Great Wolf Lodge, Chesterton, Bicester
Great Lakes UK Limited

Design & Access Statement Addendum

December 2021

This document has been prepared by EPR Architects in collaboration with the wider design team, to be read as an addendum to the original 2019 application (Application Ref. 19/02550/F (Appeal Ref: APP/C3105/W/20/3259189)).

Bay F  
Proposed Typical Bay Study - Conference Centre

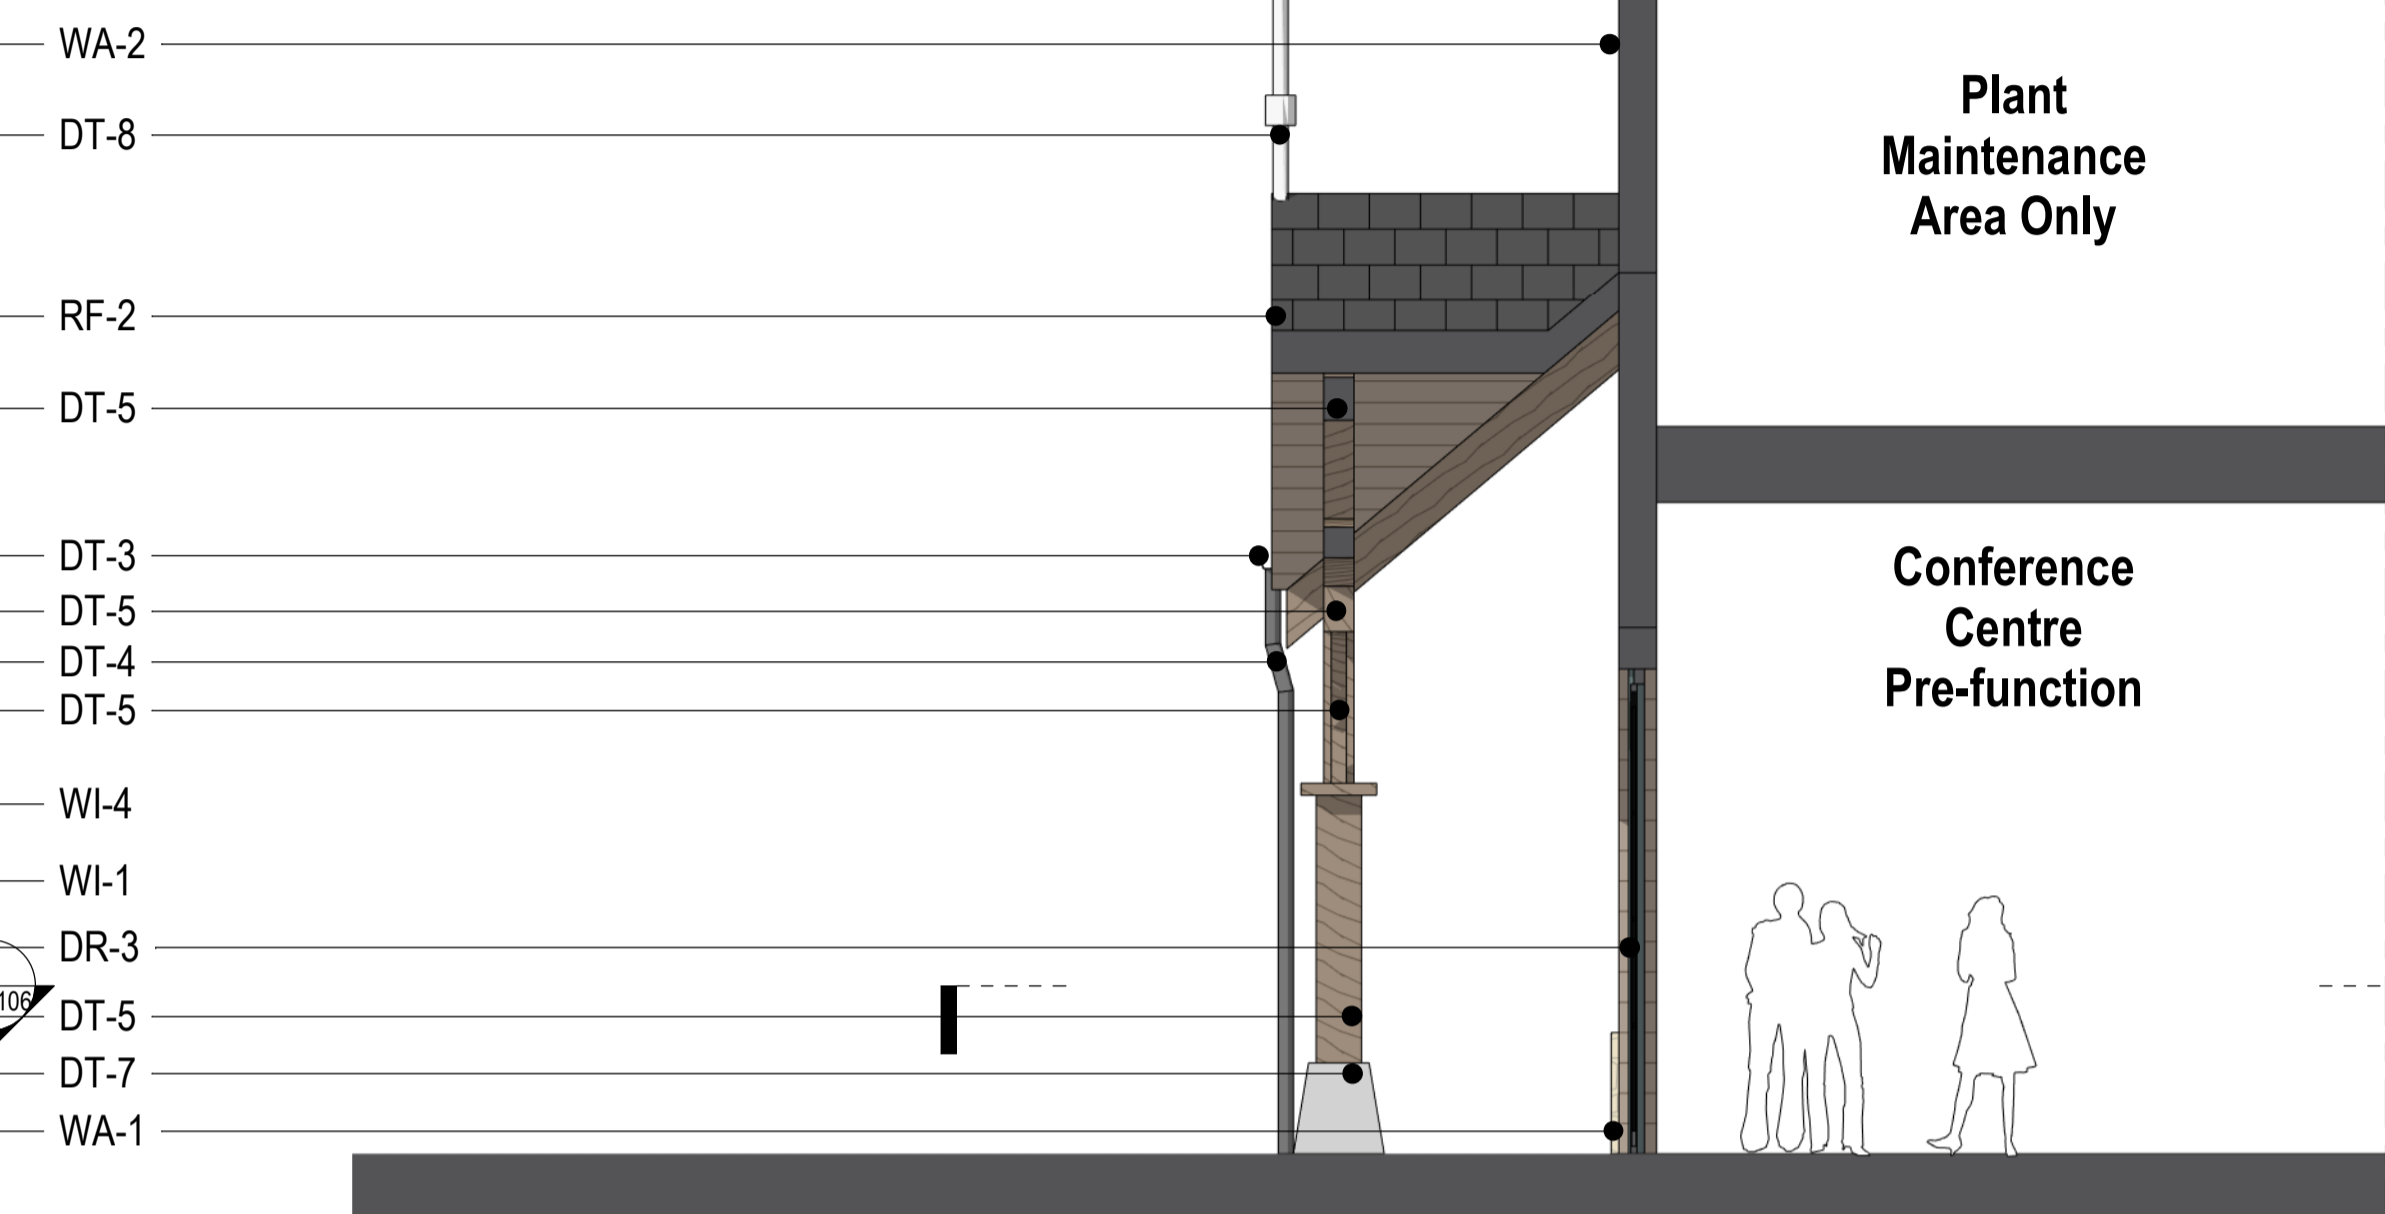
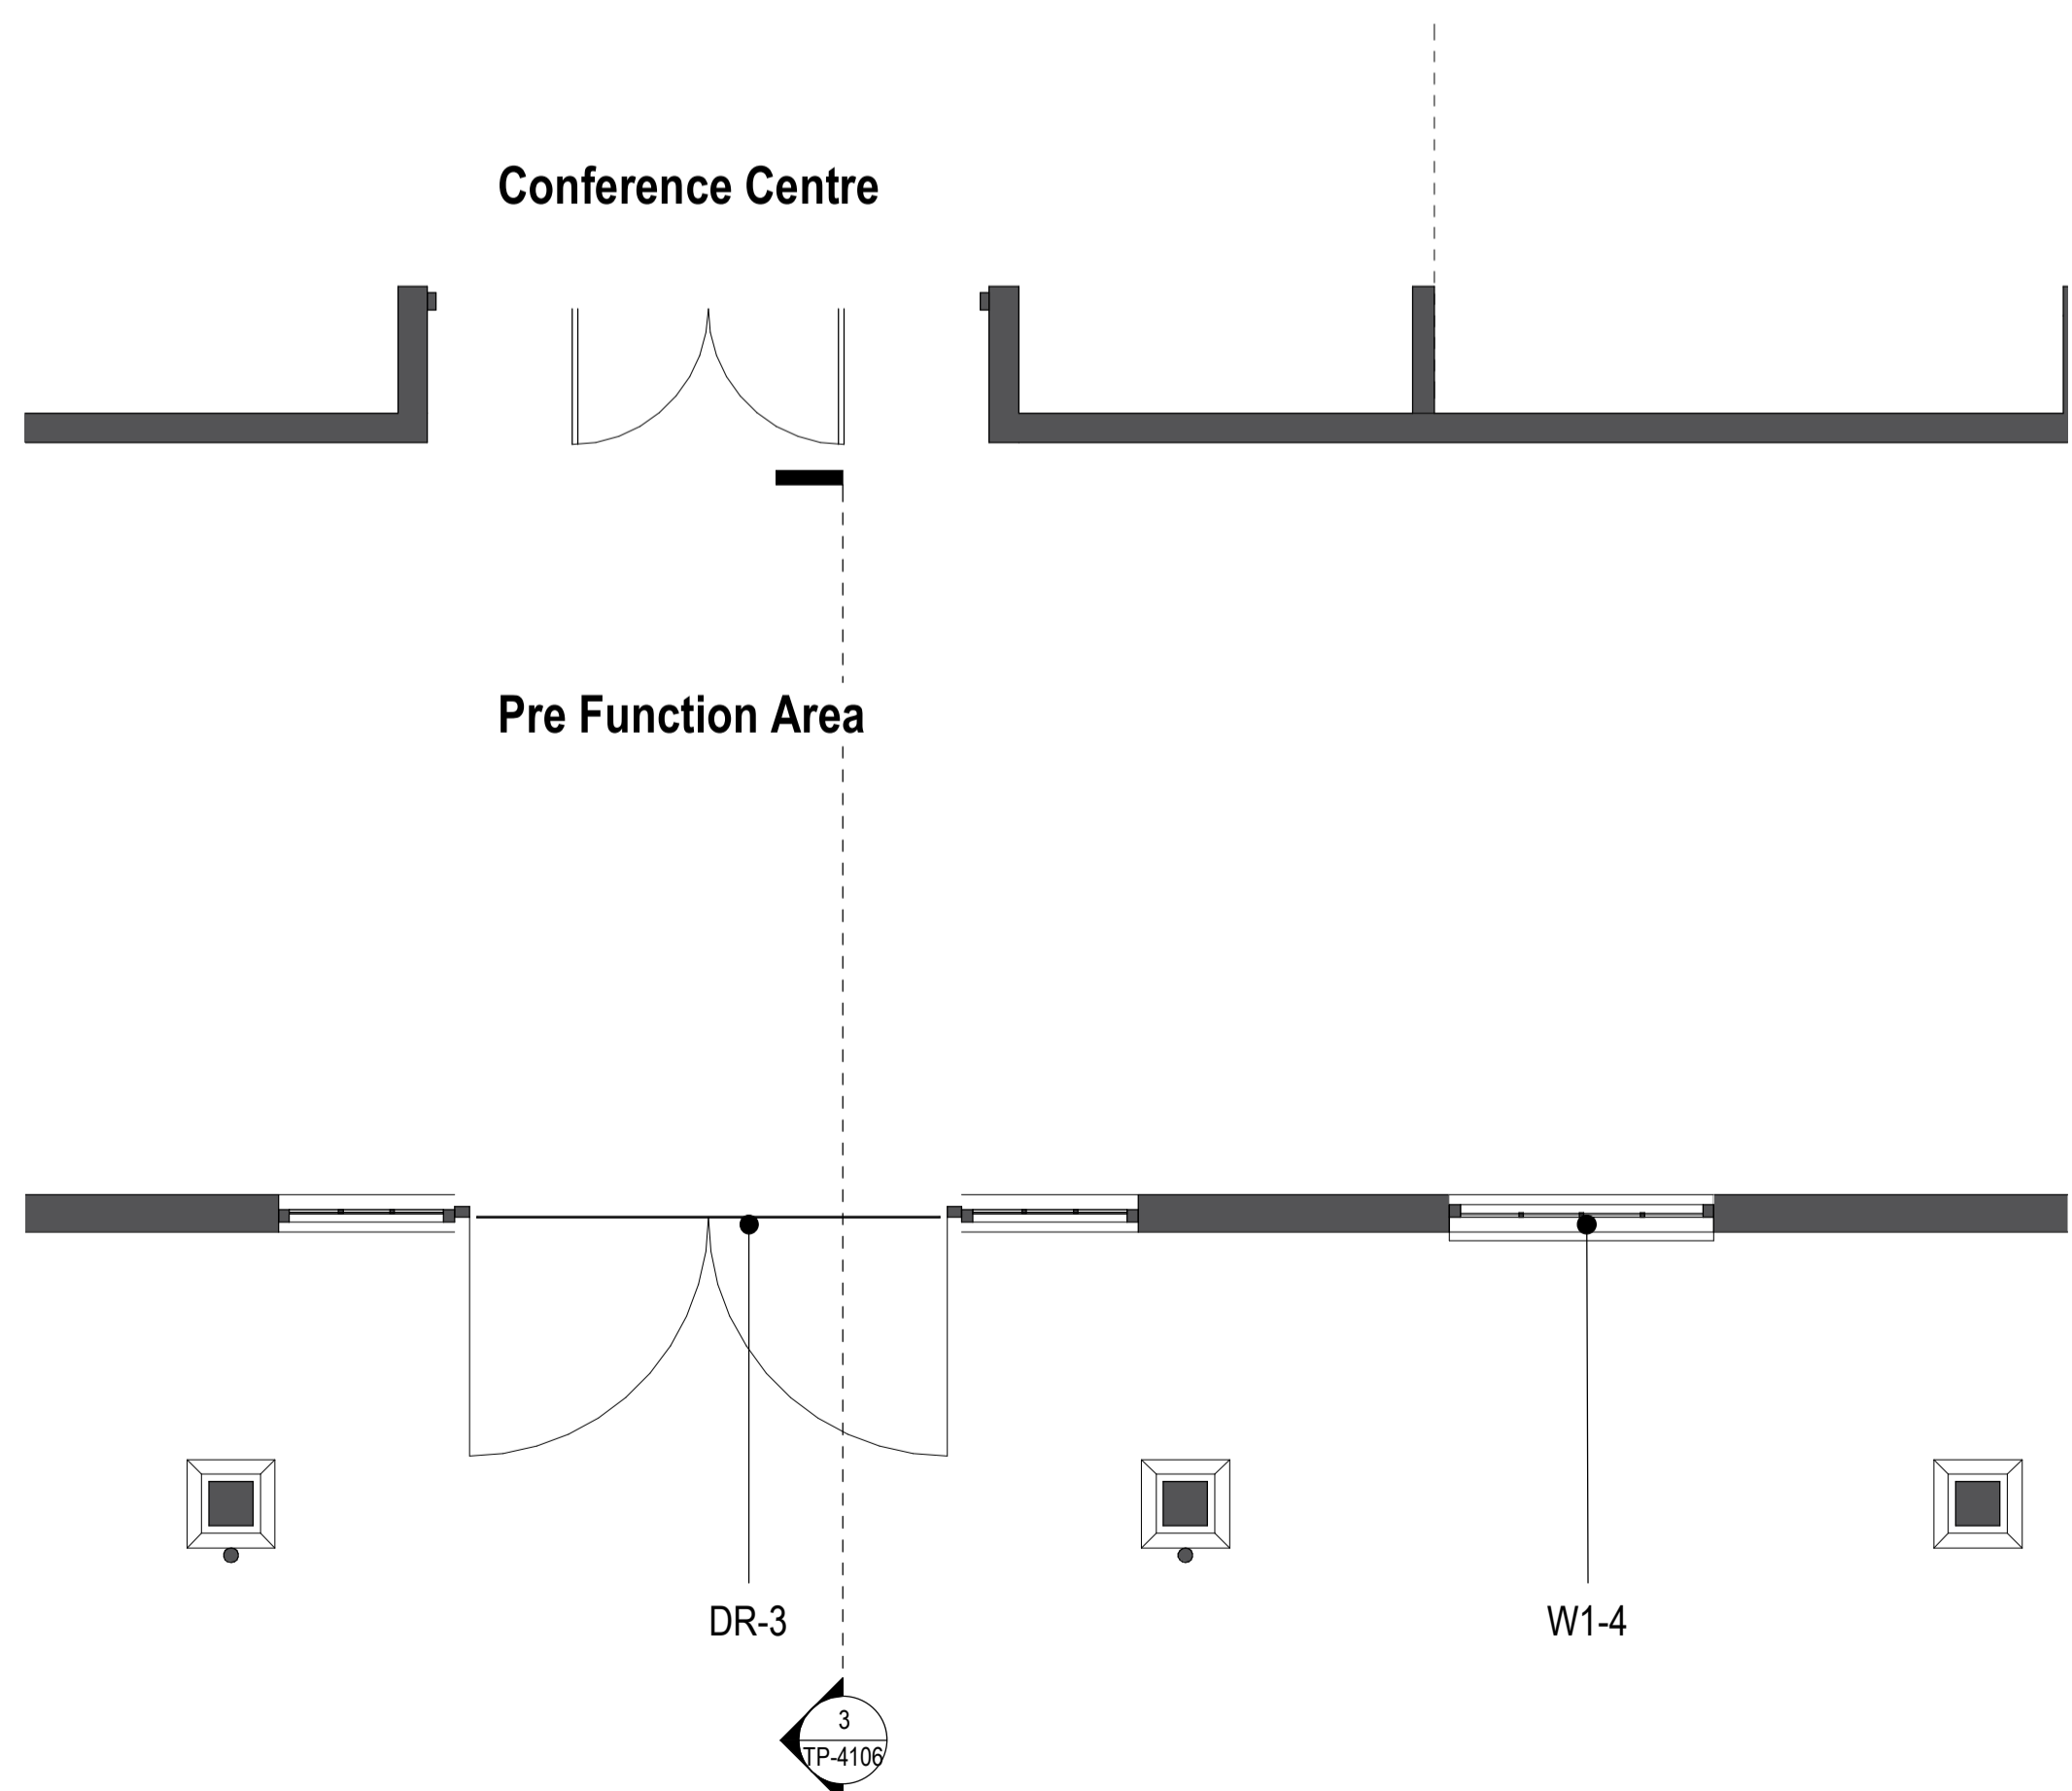
4. Re-configuration of the conference centre massing, facade design and internal layout.
5. External water park deck layouts revised and height levels updated to facilitate raised terrace zone with associated balustrade. Enlargened square to the South East corner created to host new outdoor whirlpool design.
